Consultation Response from: KC Environmental Health (Pollution & Noise Control)
2023/92317 Newsholme Food Group, New Hey Road, Oakes, Huddersfield, HD3 4BZ
Erection of extensions to form production and warehouse areas
Date Responded:
11 March 2024
Responding Officer:
RM, MN
Responding Ref:
WK/202404506

Wooltex UK Ltd are an established textile company which has recently taken over the premises on New Hey Road to allow for an expansion of the spinning part of the business. The application seeks permission to extend the premises by constructing extensions to the existing building to provide better use of space and working systems. We have reviewed the application and supporting information and make the following comments and recommendations.

Figure 1. The existing Wooltex Spinning Company Ltd facility and the surrounding areas

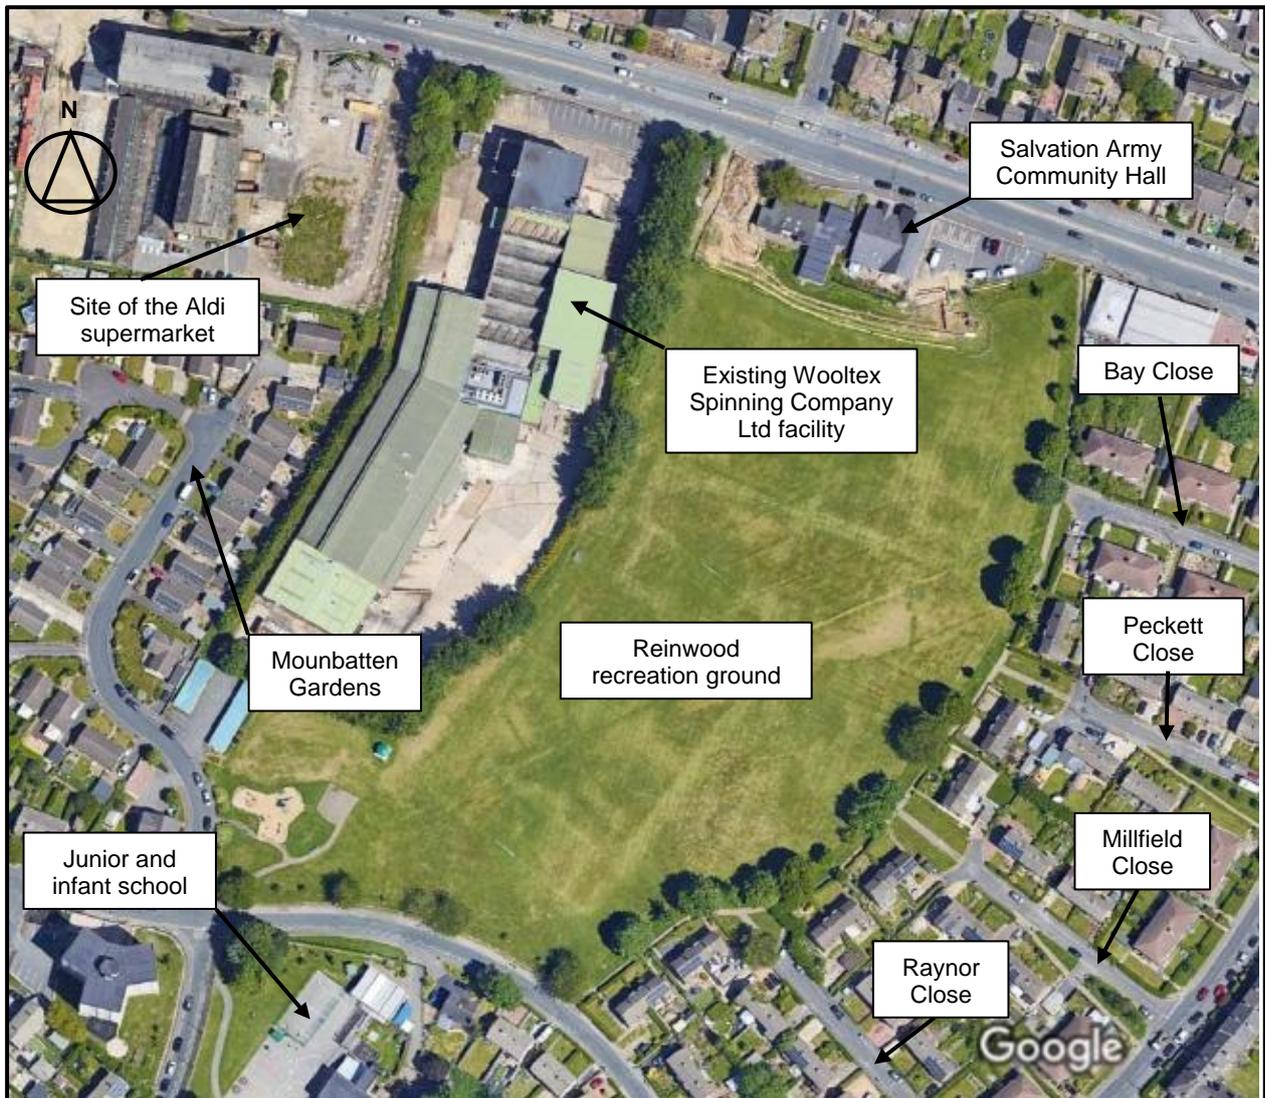
A Noise Assessment has been submitted authored by Druk Limited dated 20 October 2023 Ref DRUK/ACC/RS/WSCLNHRH/3246. Para 3 describes the site location with figure 1 showing the surrounding areas and the nearest noise sensitive receptors (NSRs), namely Mountbatten Gardens, Bay Close, Peckett Close, Millfield Close and Raynor Close to the West, East and South East of the existing facility.

Figure 3. Approximate location of the measurement positions

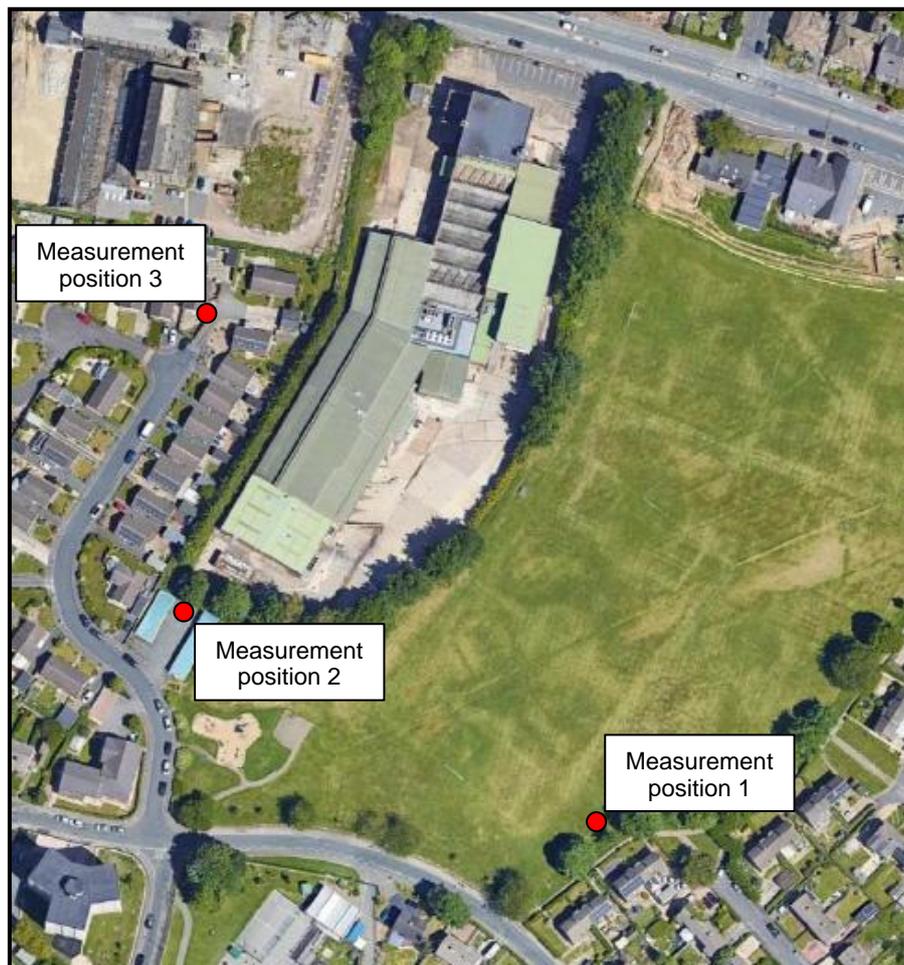
Noise surveys were undertaken between 1400hrs to 1600hrs and 2100 to 2300hrs on the 12th of October, between 1000hrs to 1200hrs on the 16th of October and between 0200hrs to 0300hrs on the 17th of October 2023 from 3 measurement positions (MPs) as shown in figure 3. The report states overall, the existing noise climate was believed to be characteristic of a largely sub-urban environment subject to noise contributions from: process noise from the existing Wooltex facility, road traffic noise, noise from the infant and junior school and some noise associated with the surrounding residential premises. A summary of the findings is given in table 2 (MP1), table 3 (MP2) and table 4 (MP3).
